Inspector's Addendum Report ABP-320049-24

Construct 267 residential units, a childcare facility, a link road, road upgrades along the Old Navan Road (R157) and associated development

Bennetstown, Pace & Dunboyne townlands, Dunboyne, County Meath

Drawing file: Applicant Further Information Response / f.i. terrace f - house type x second floor & roof plans.pdf

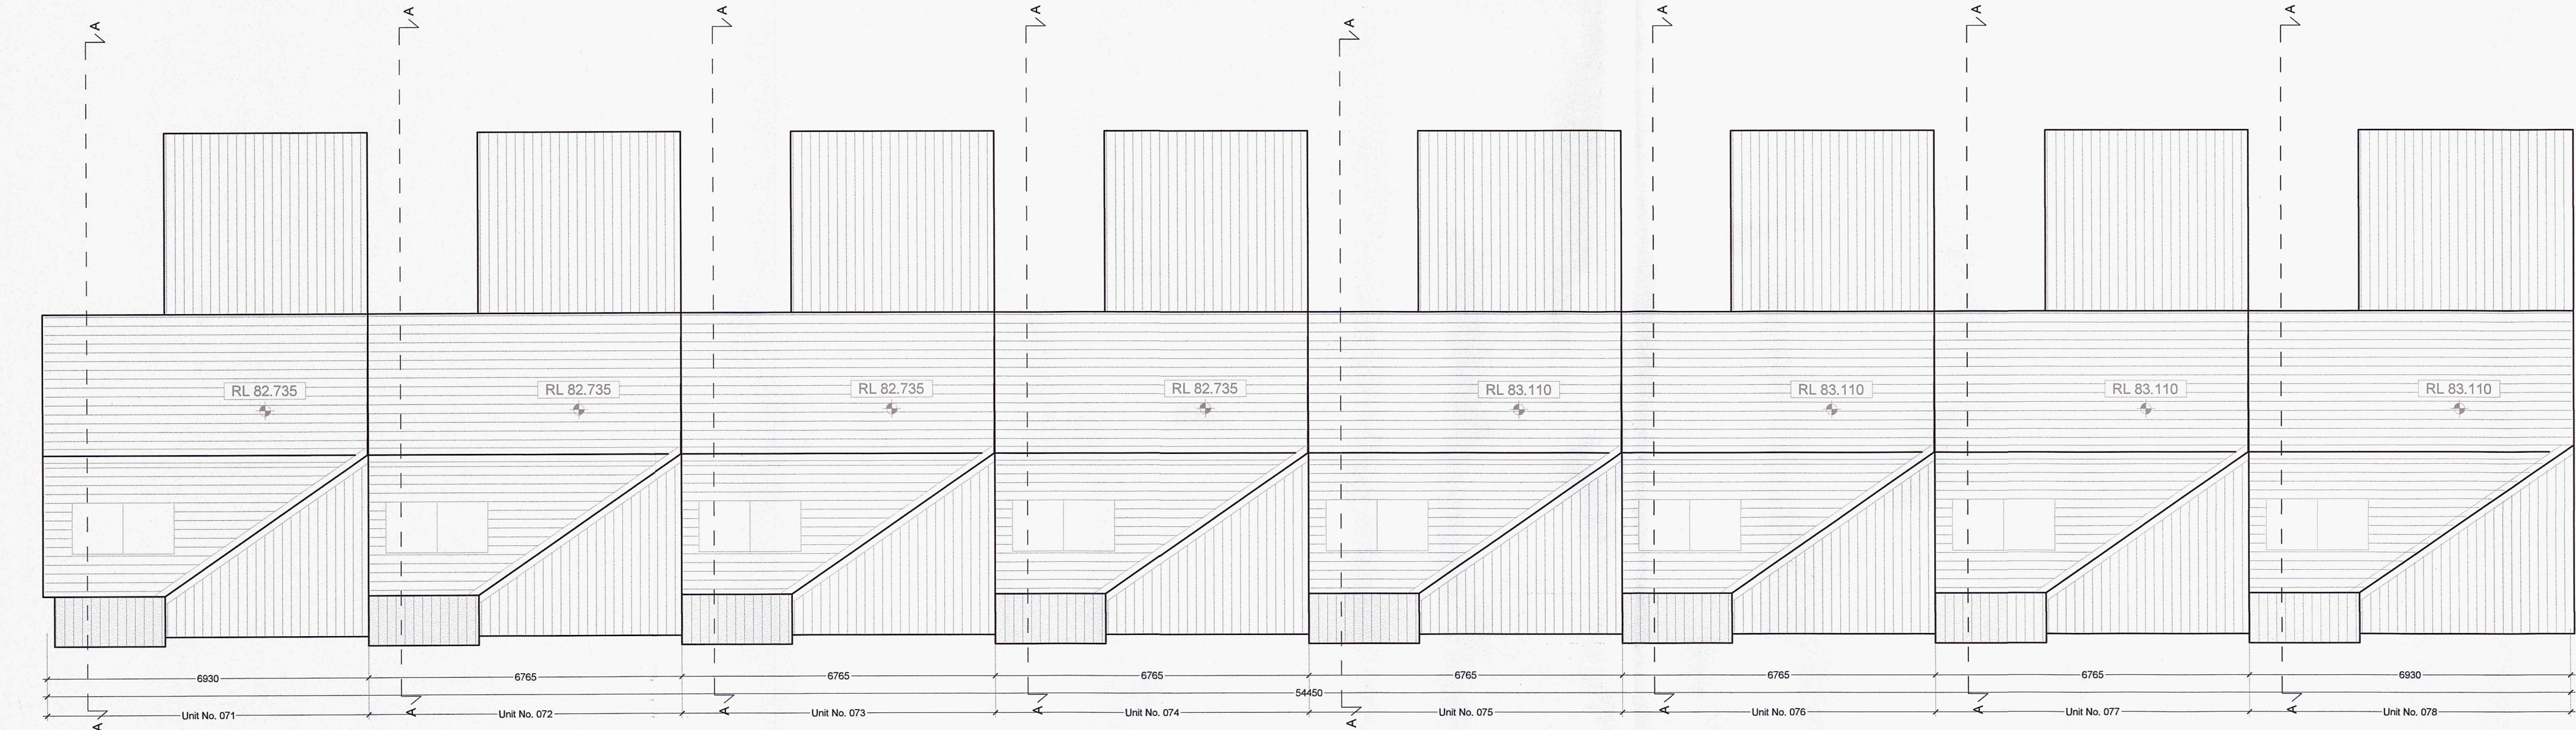
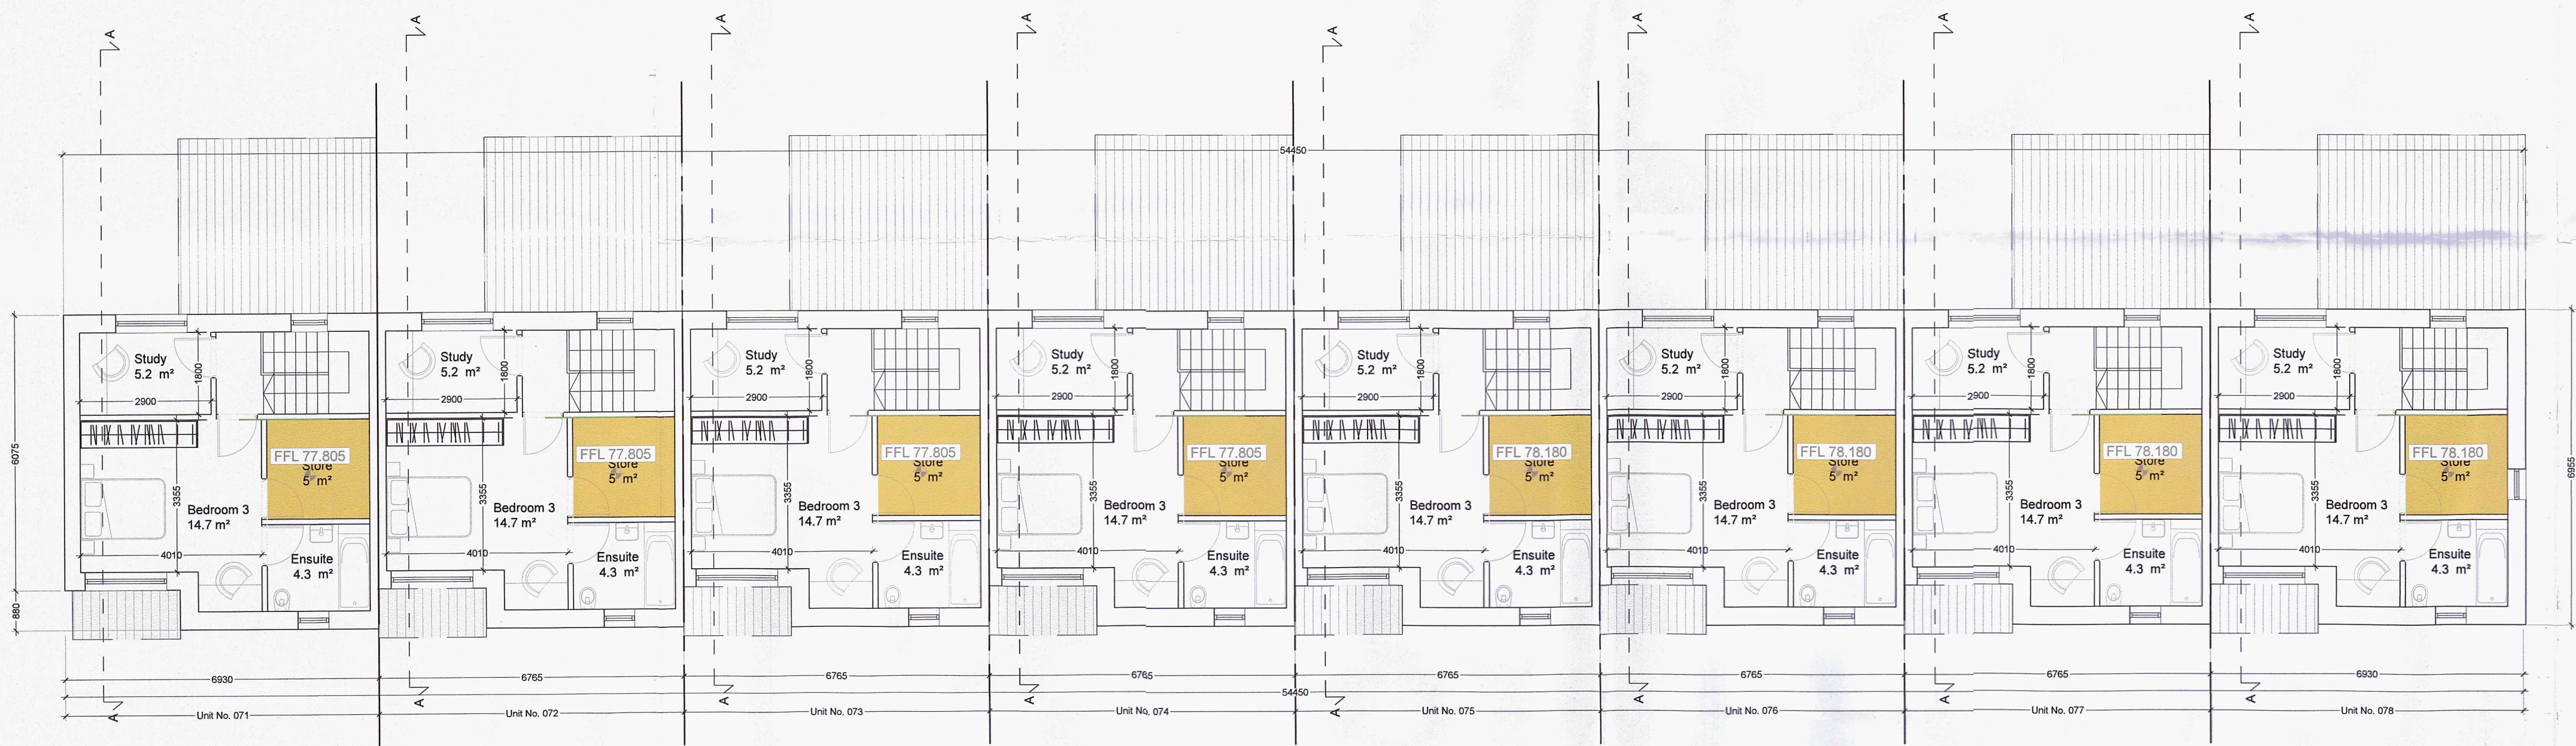
- 2.6.8. With the additional provision of 4.7sq.m rear terrace areas, a minimum of 20sq.m private open space would be provided for each of the subject townhouses in blocks D, E and F. Furthermore, well in excess of the 20sq.m high-quality communal space per townhouse would be integrated and accessible directly from the respective townhouses in blocks D, E and F, in lieu of the private open space. Accordingly, I

am satisfied that with the attachment of a condition providing for private rear terrace / patio areas measuring a minimum of 4.7sq.m, featuring a formal boundary treatment and accessible off the living / dining areas to blocks D, E and F, the townhouses in these blocks would be provided with private amenity space, as well as integrated, high-quality communal space to align this element of the proposals with the requirements of SPPR 2 of the Guidelines.

- (b) each townhouse in blocks D, E and F shall be provided with a rear private terrace / patio area defined with a formal boundary treatment and measuring a minimum area of 4.7sq.m, with direct access to the private terrace / patio areas from the living / dining areas of each of the respective townhouses in blocks D, E and F;
